**Re: West Dapto Urban Release Area and Adjacent Growth Areas  
Proposed Water and Wastewater Services.  
Environmental Assessment Report.  
Reference: 09 \_ 0189**

### **WEST DAPTO URBAN RELEASE AREA and ADJACENT GROWTH AREAS**

#### **Proposed water and wastewater services**

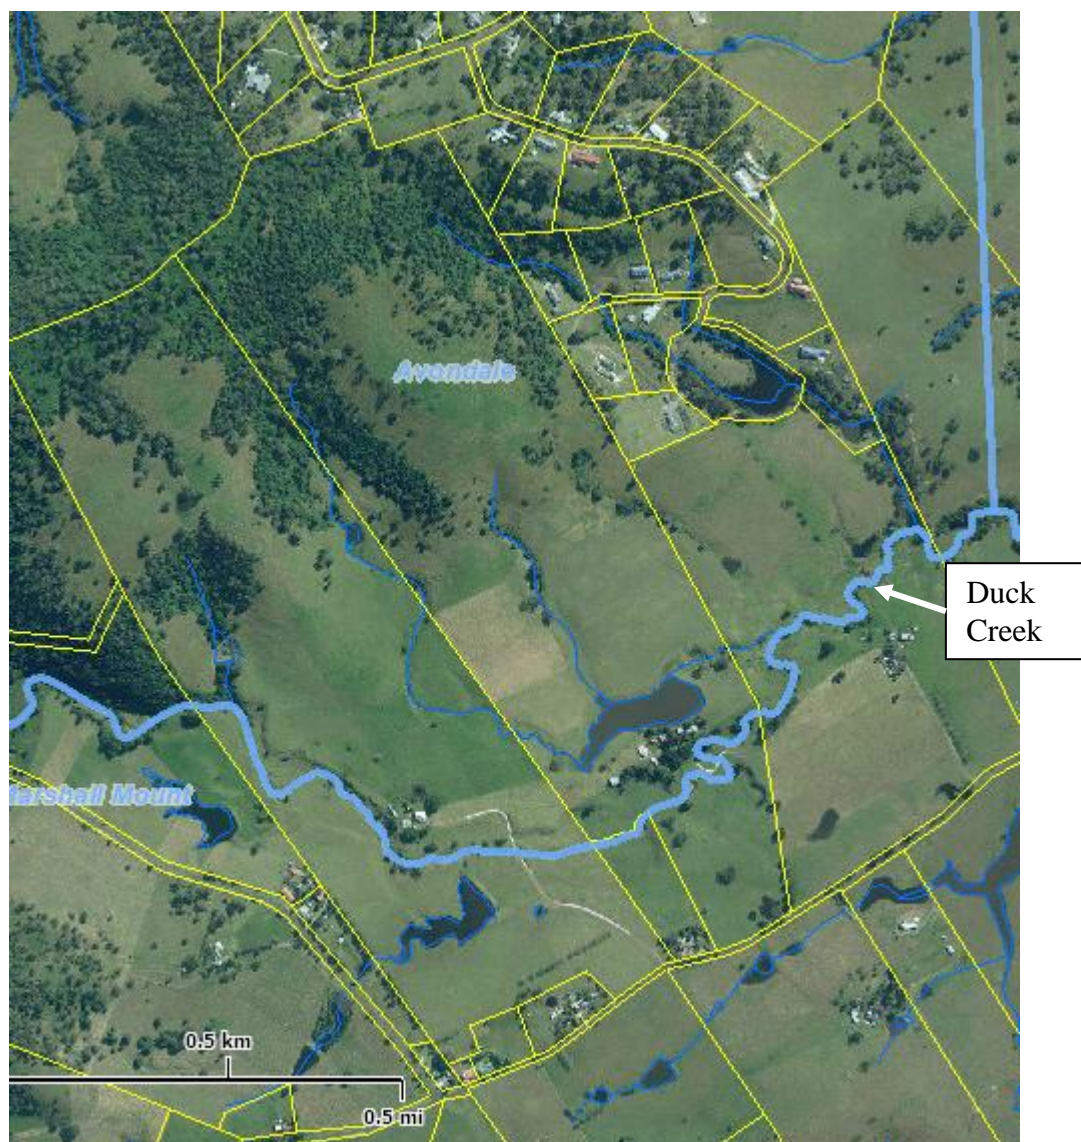
**1 There exists an apparent discrepancy in discharge loads to wastewater trunk pipelines servicing Yallah/Marshall Mount precinct.**

- Two wastewater trunk pipelines are planned west of the proposed wastewater pumping station.
- These two wastewater trunk pipelines will carry very different discharge loads because of the numbers of lots they will service.
- The wastewater trunk pipeline servicing the western end of Marshall Mount Road and North Marshall Mount Road will carry at least four times the discharge load.
- For this reason and others detailed below, the wastewater trunk pipeline servicing the western end of Marshall Mount Road and North Marshall Mount Road should be extended to North Marshall Mount Road.
